**Consultation Response from KC,
Lead Local Flood Authority**

2025/93057 Land off, Hermitage Park, Lepton, Huddersfield, HD8 0JU

Discharge of details reserved by conditions 27 (BEMP) , 28 (swale), 29 (surface water) and 30 (storm modelling) of previous permission 2025/90105 for variation of conditions 6 (PROW), 9 (boundary treatment), 38 (bin collection), 40 (car parking) and 41 (access) of previous outline permission 2022/91735 (with access and layout) for erection of 80 dwellings and associated works

Date Responded: 3rd December 2025

Drawing Title: **PLOT 7 AND 8 EXCEEDANCE FLOW ROUTING**

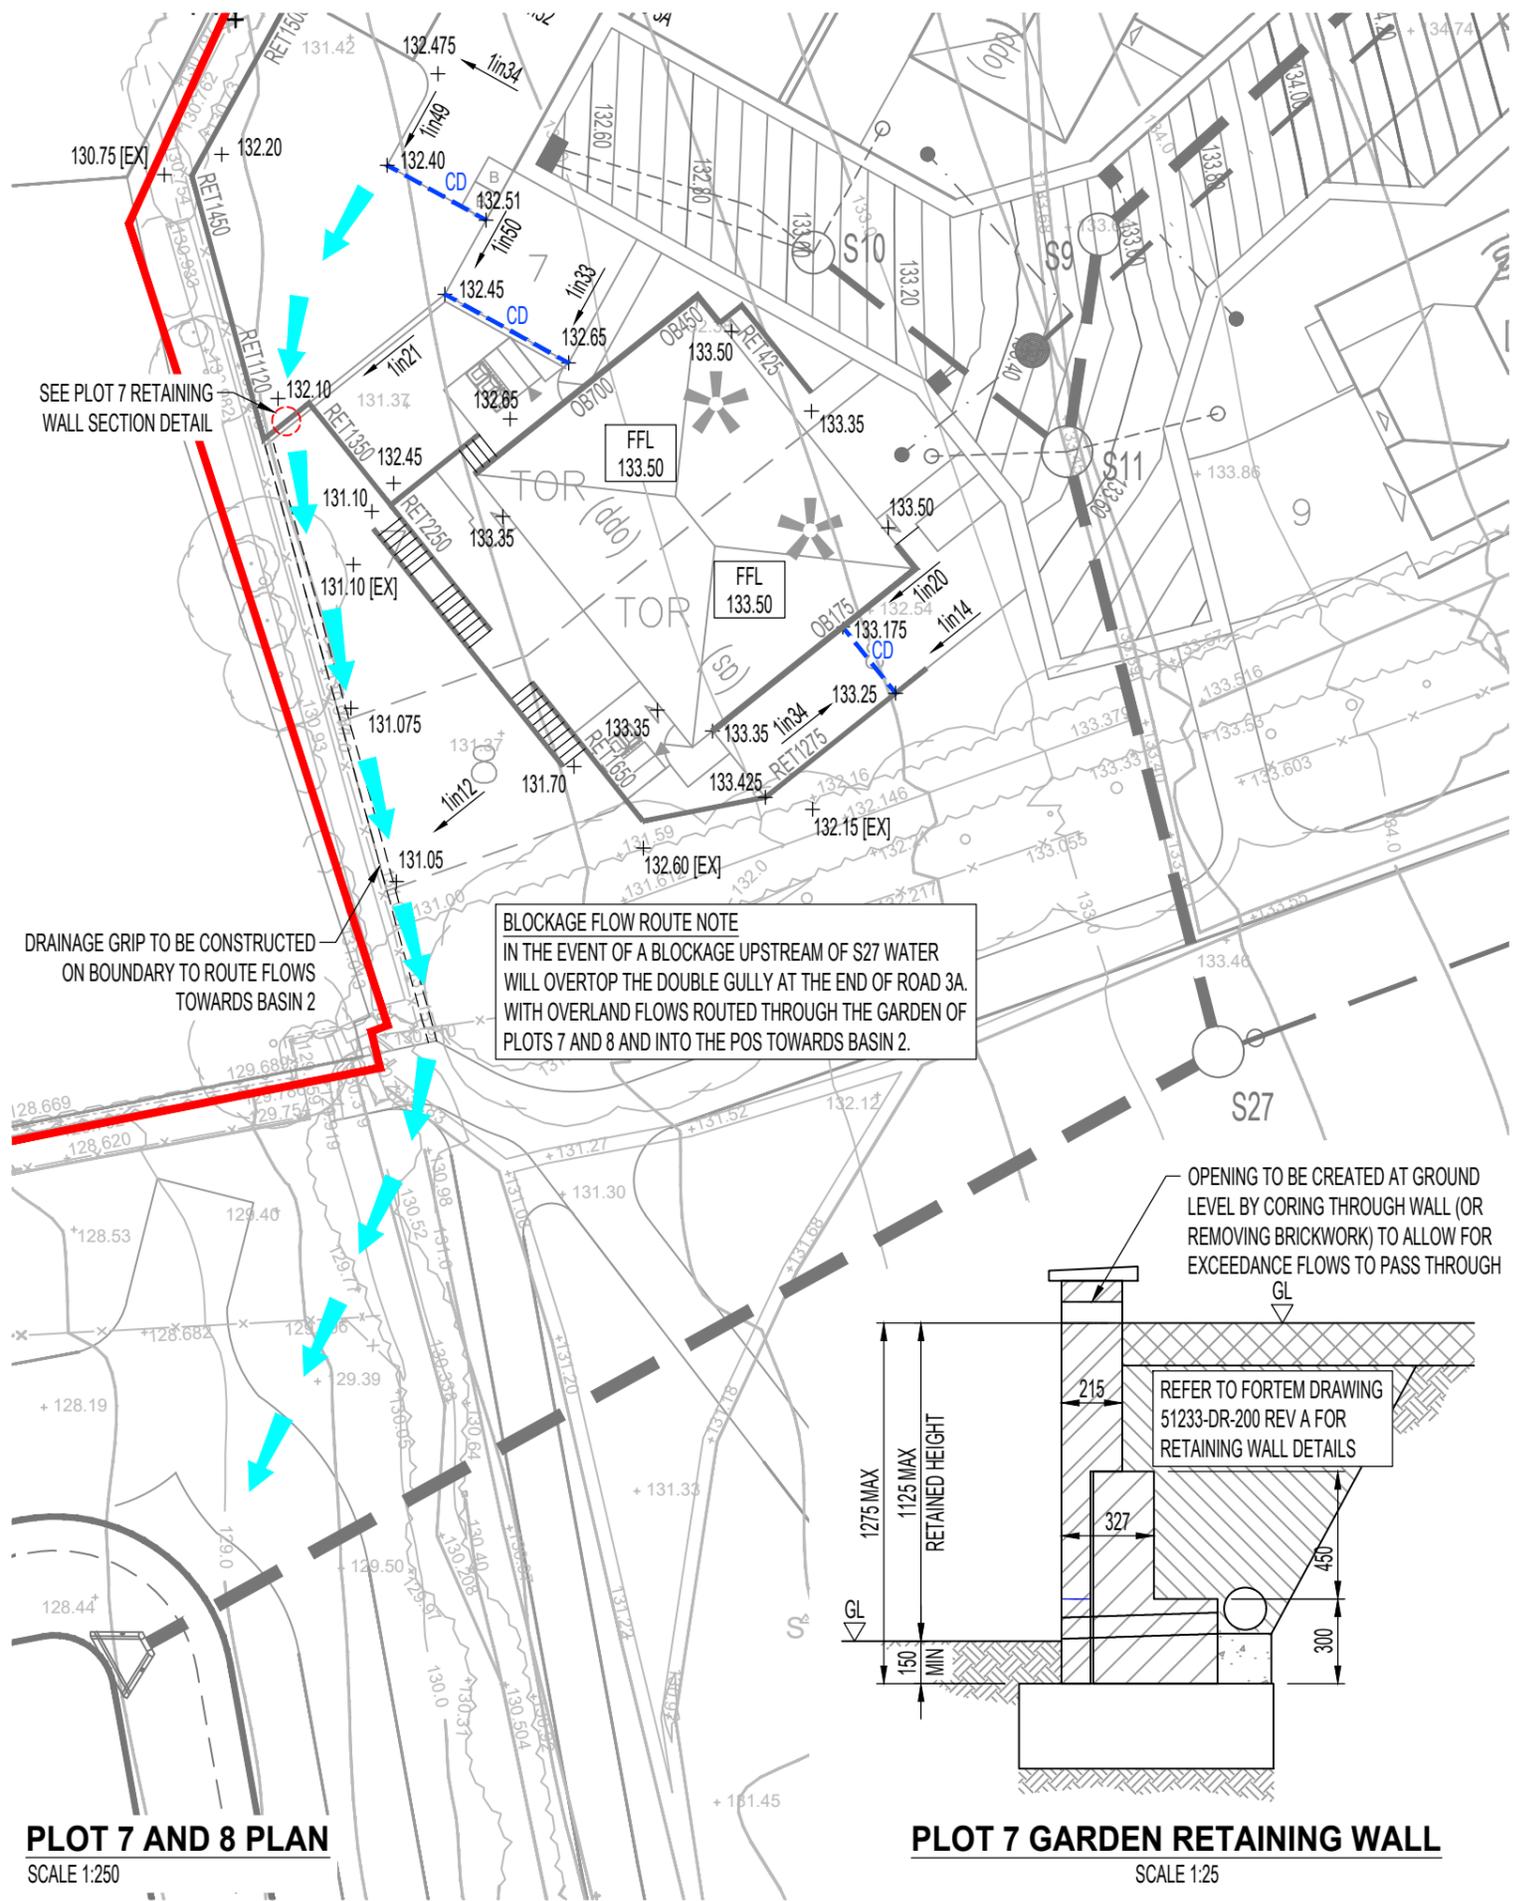
The flood routing through rear gardens of plots 7 and 8 has previously been discussed and approved in principle without prejudice to future applications. A detailed level layout plan concentrating on these two plots including gullies and low levels in the driveway, unobstructed boundary details etc, is required for completeness.

Drawing Title: **EASTERN BOUNDARY LAND DRAIN AND BOARDWALK DETAILS**

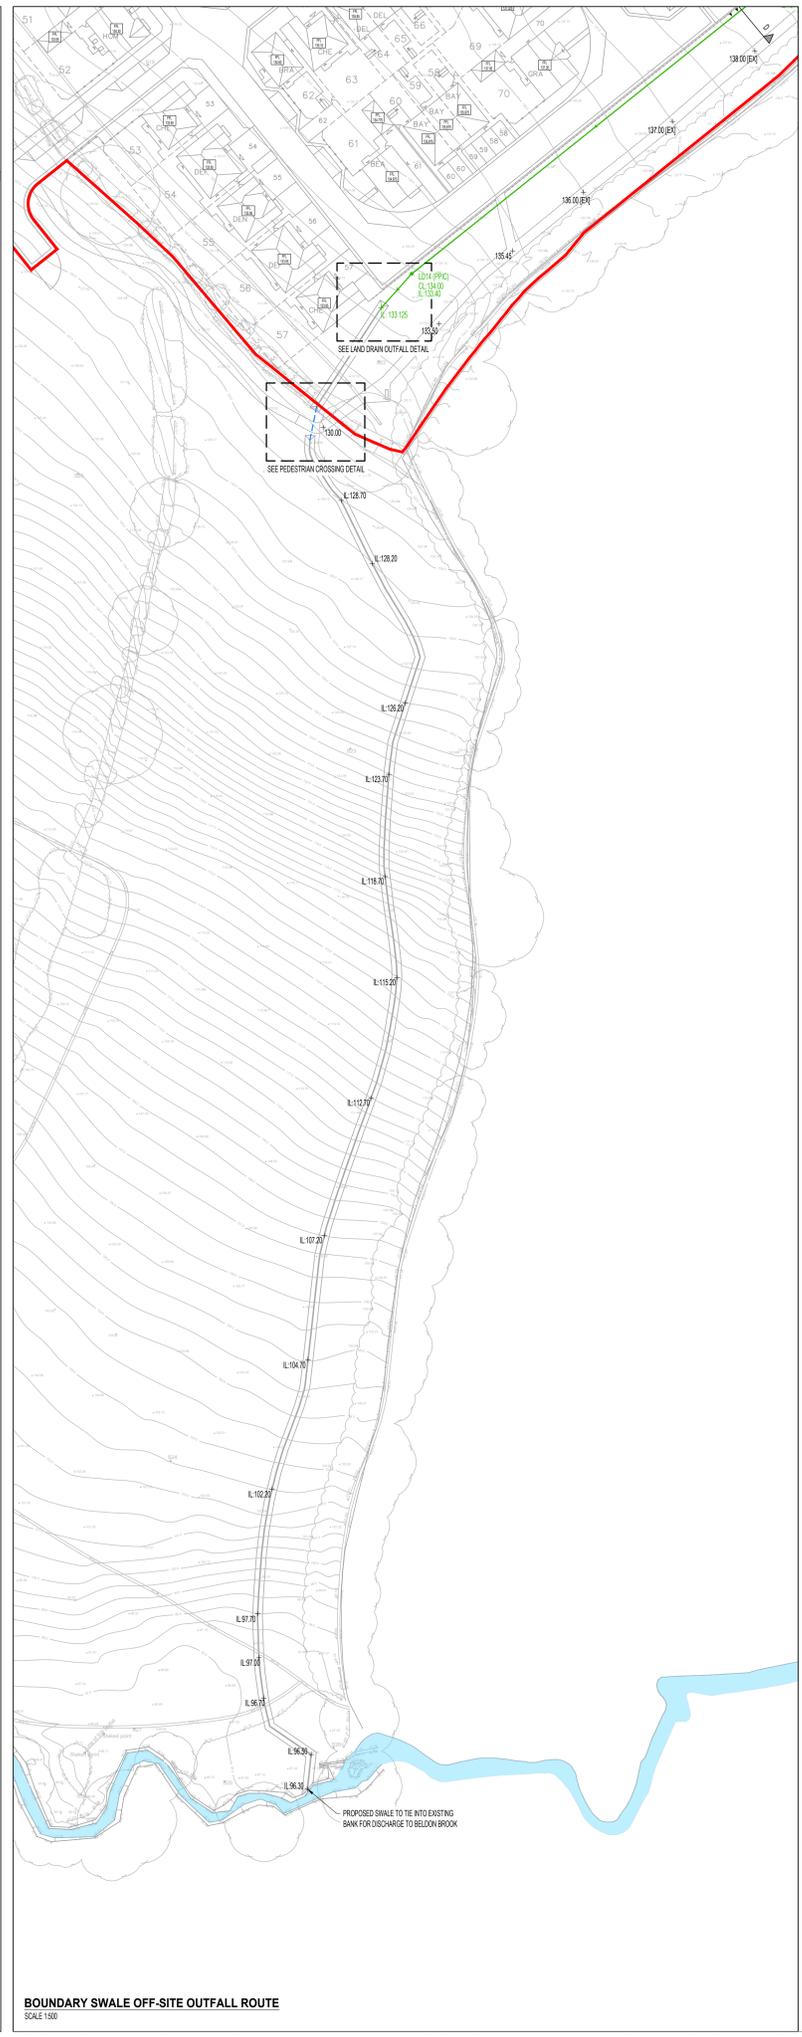
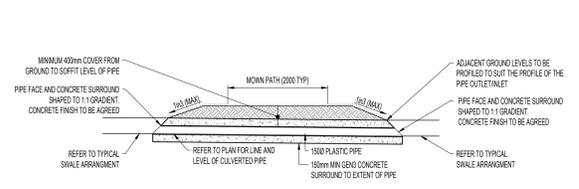
Due to issues with tree roots we have agreed that part of the swale can become a pipe. Drawings should clearly label an interceptor trench to guide water to the inlet. A risk assessment should be made around whether a trash screen or simple safety screen should be erected at inlets and outlets.

ATTENUATION BASIN DETAILS
BASIN 1

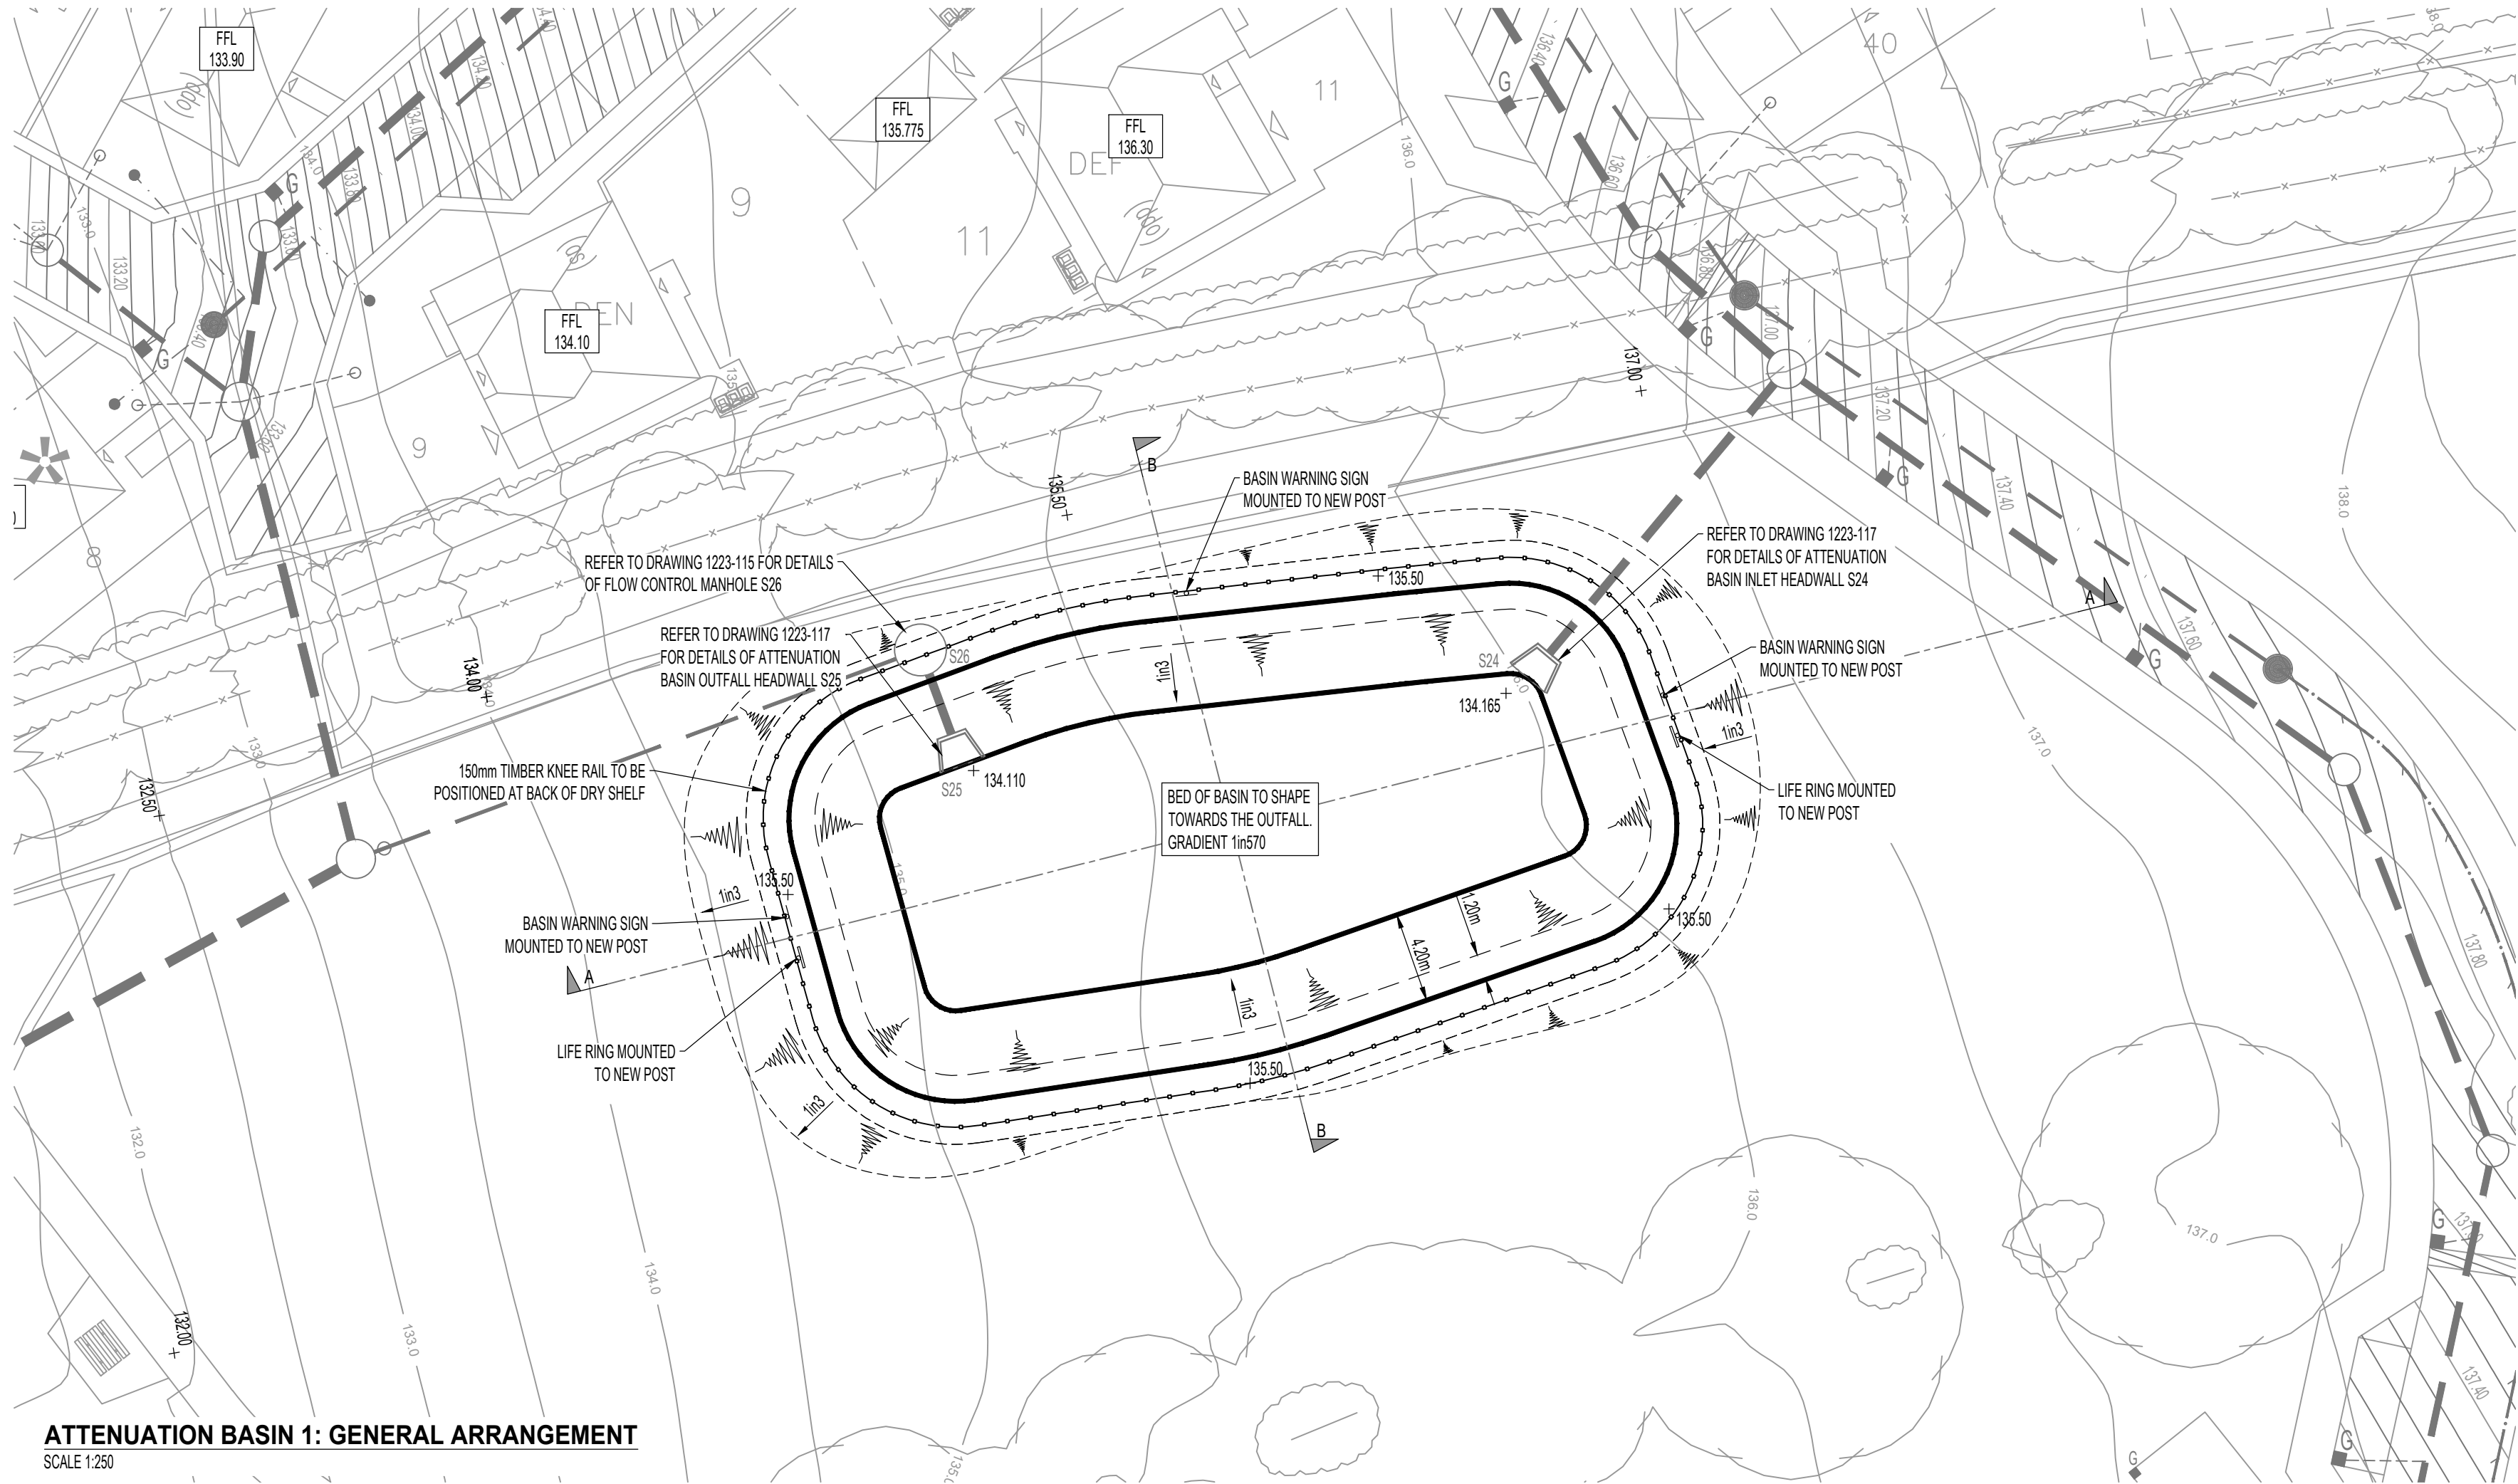
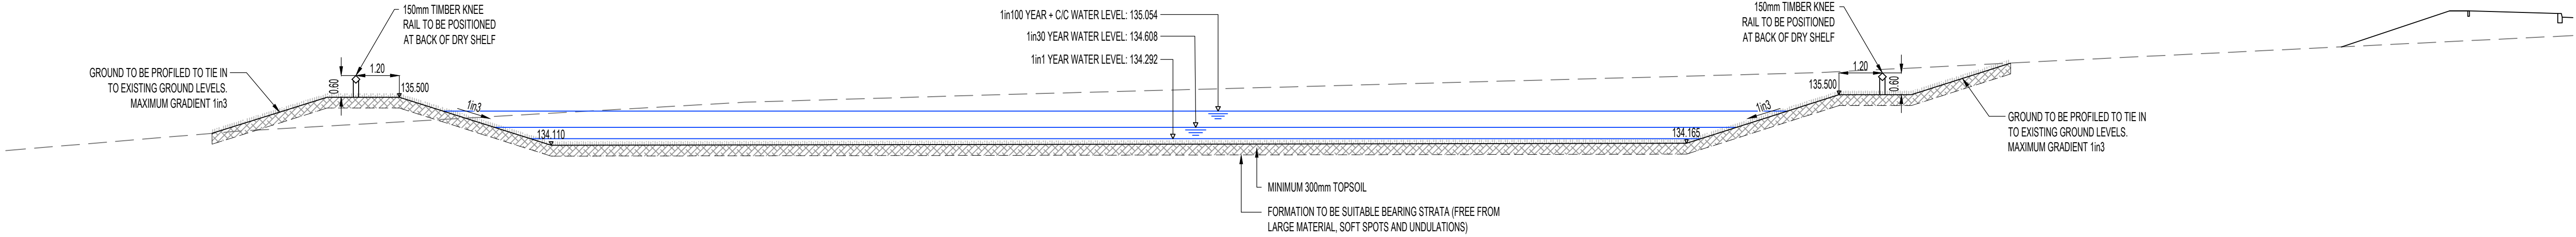
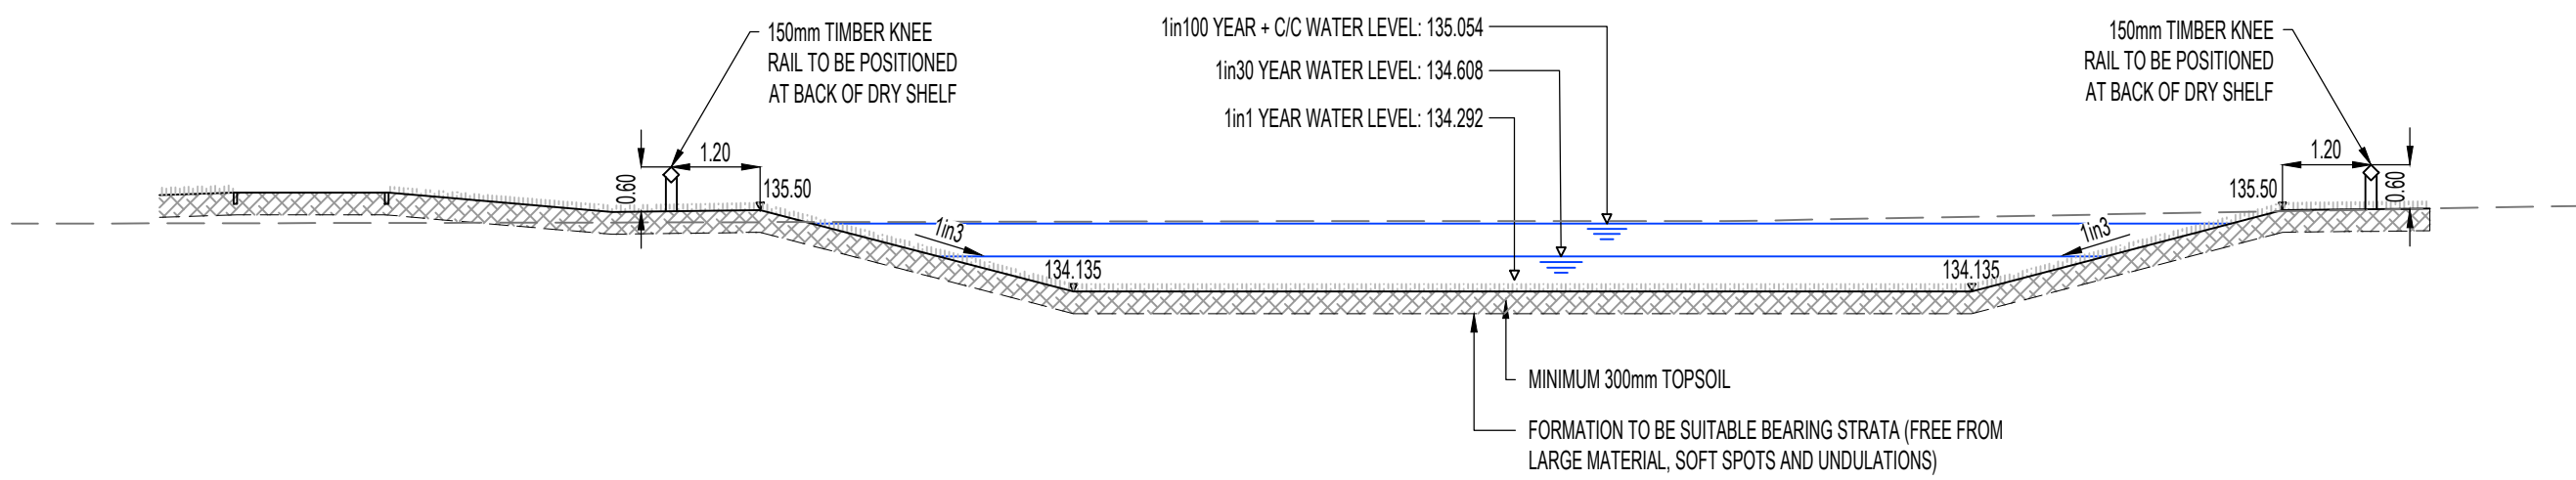
Basins are shown at 1 in 3 slopes and less than 1m of water in storm conditions. Measurements of length/width at the top and bottom should correspond to any basin data entered into a storm wizard on an appropriate hydraulic model.
